William Simcock
Kirklees Metropolitan Borough Council
Development Management

Our ref: RA/2024/147770/05-L01
Your ref: 2024/91476

ERECTION OF 24 DWELLINGS – CLOUGH FARM, LONG LANE, EARLSHEATON, DEWSBURY, WF12 8LQ

Thank you for re-consulting us on this application following submission of additional ecology information / amended plans, which we received on 4 April 2025.

Project - Originator - Zone - Level - Type - Role - Number	Status	Rev
LLE-BWB-ZZ-XX-DR-LE-0002	S2	P03

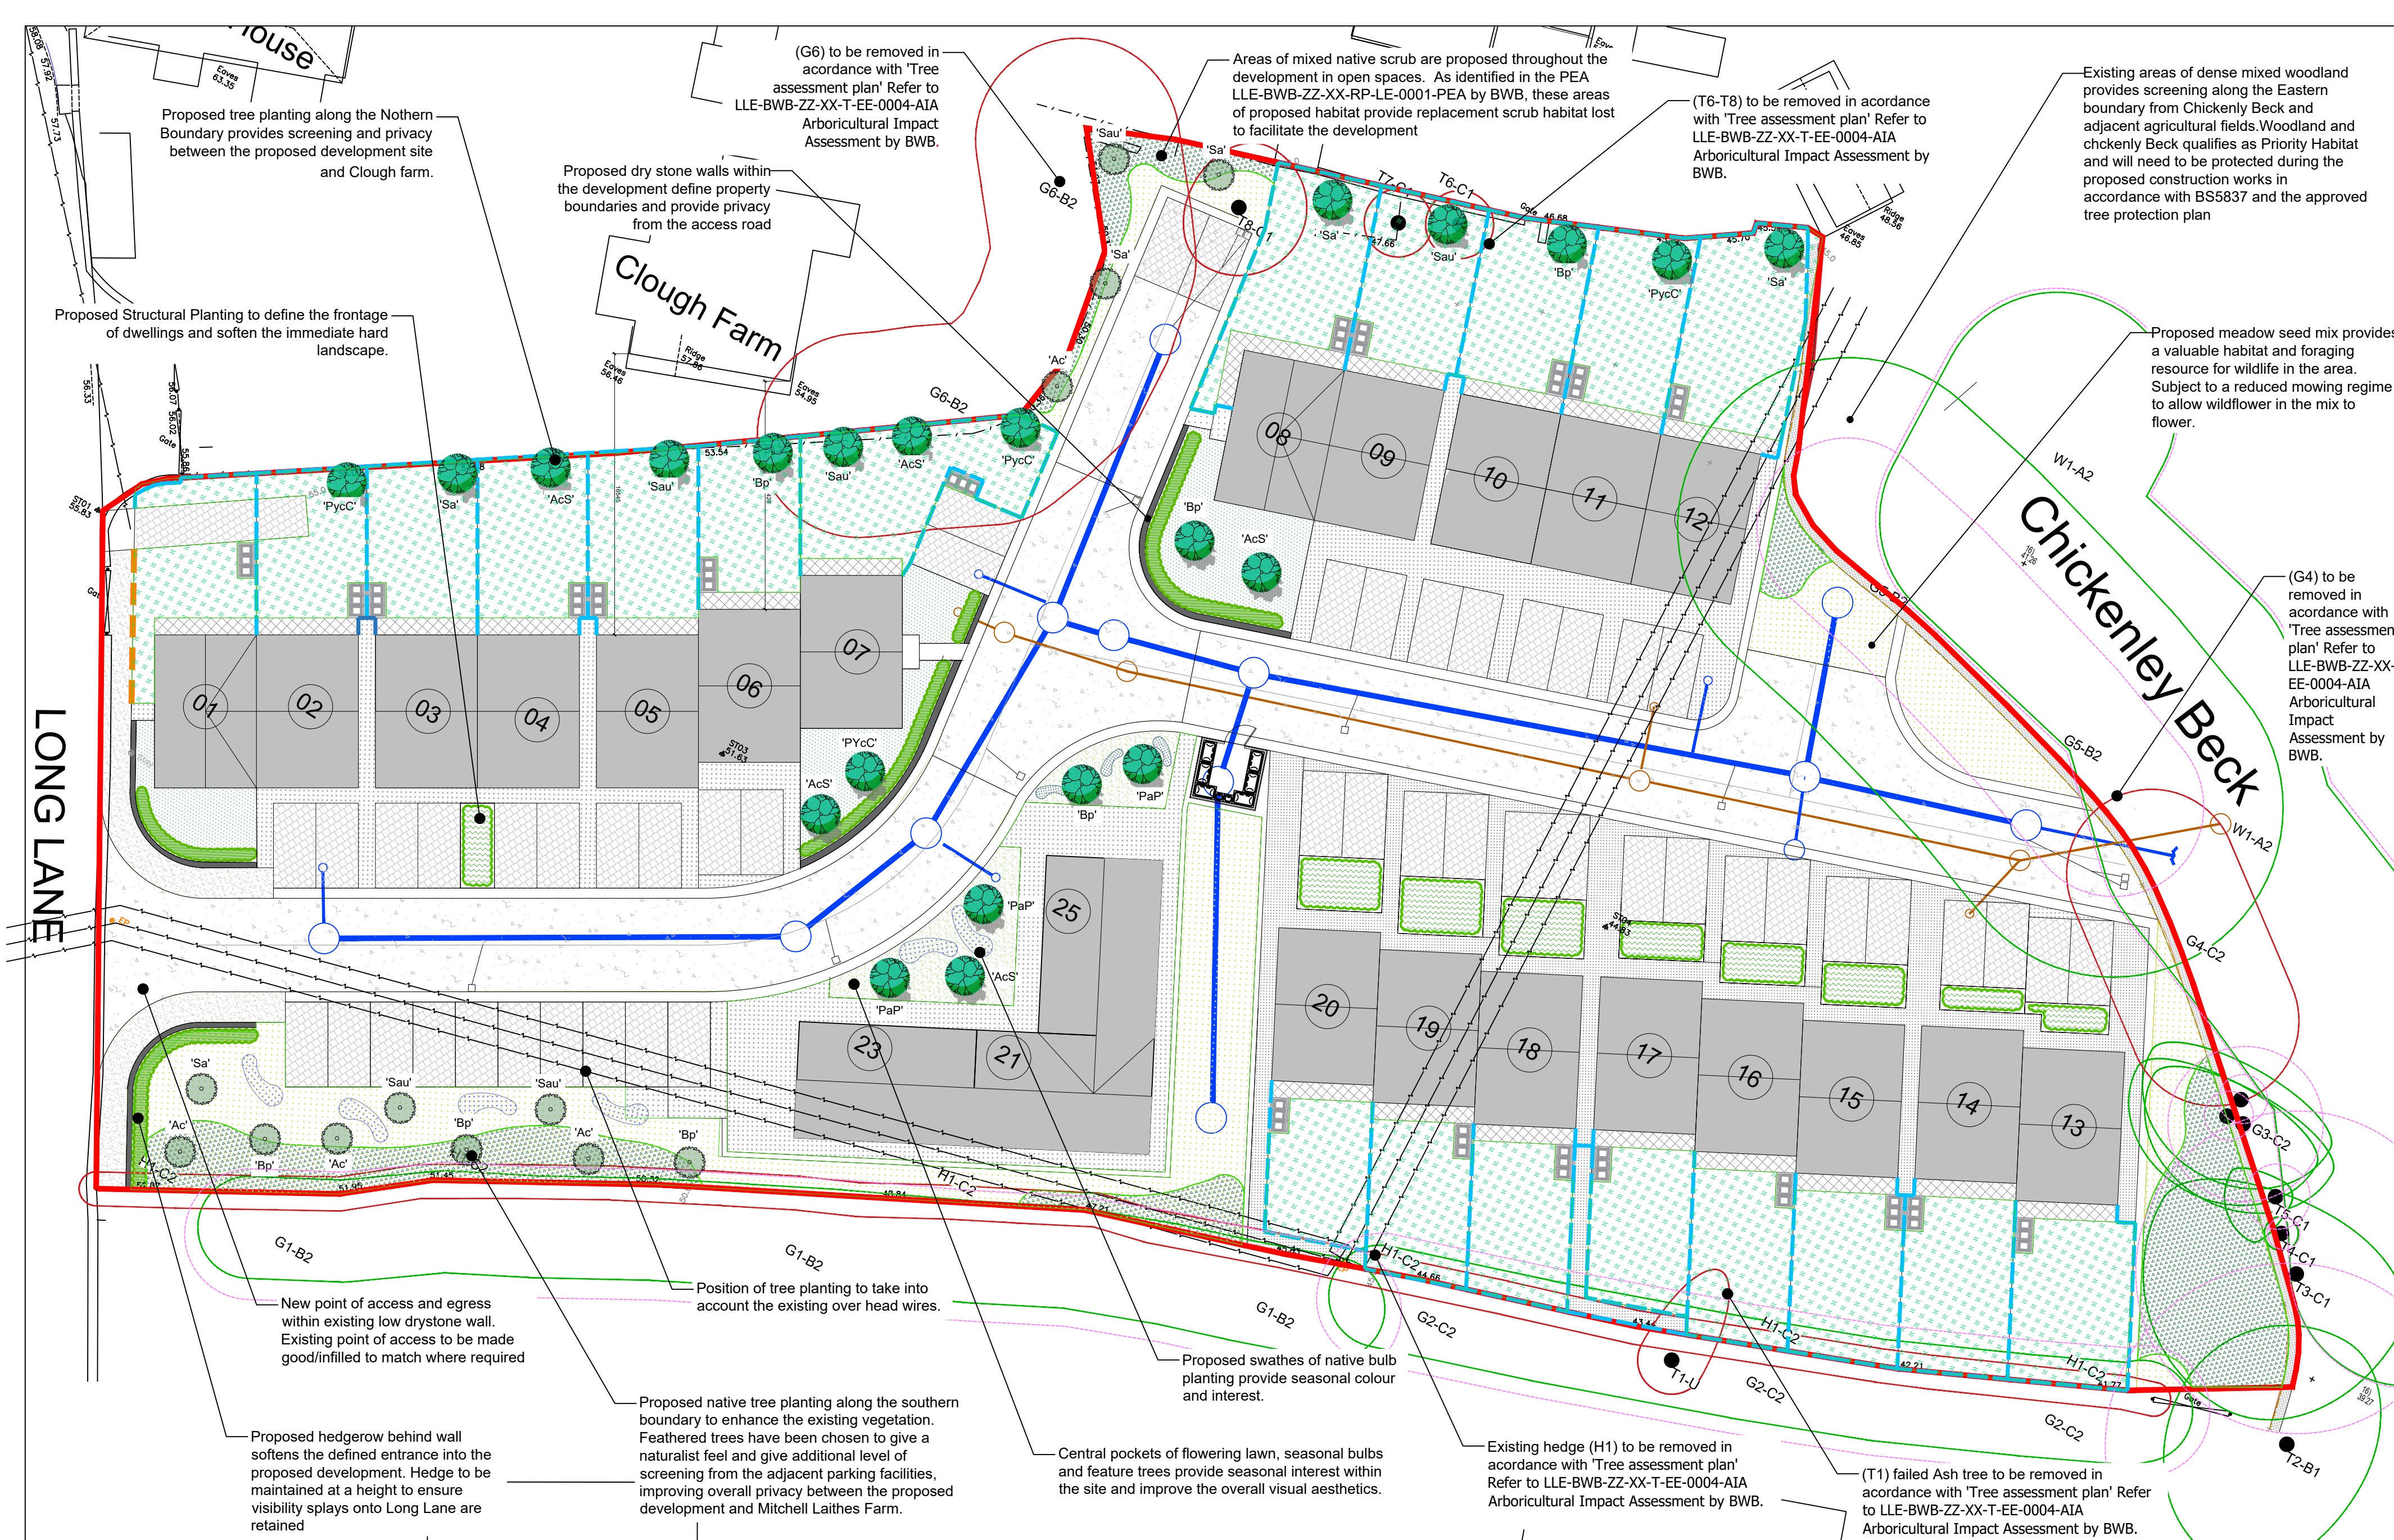
As the development includes building housing, parking spaces and a road in the riparian zone, the post development riparian encroachment will be higher than the baseline riparian encroachment as the riparian zone is currently undeveloped.

We are highlighting this and recommend that the LPA reviews the Biodiversity Metric and plans to ensure that post-development riparian encroachment is accounted for in the delivery of Watercourse Units.

The applicant has now provided a landscape plan which shows the retention of existing trees and vegetation along the river corridor, as well as providing an updated BNG statement which recognises the Watercourse Units on site and accounts for delivery of 10% uplift (dependent on revision to the post-development encroachment values provided in the metric, see informative above). As a result, the risk to the riparian zone is better known and we therefore accept that a WFD Assessment for the development is no longer necessary.
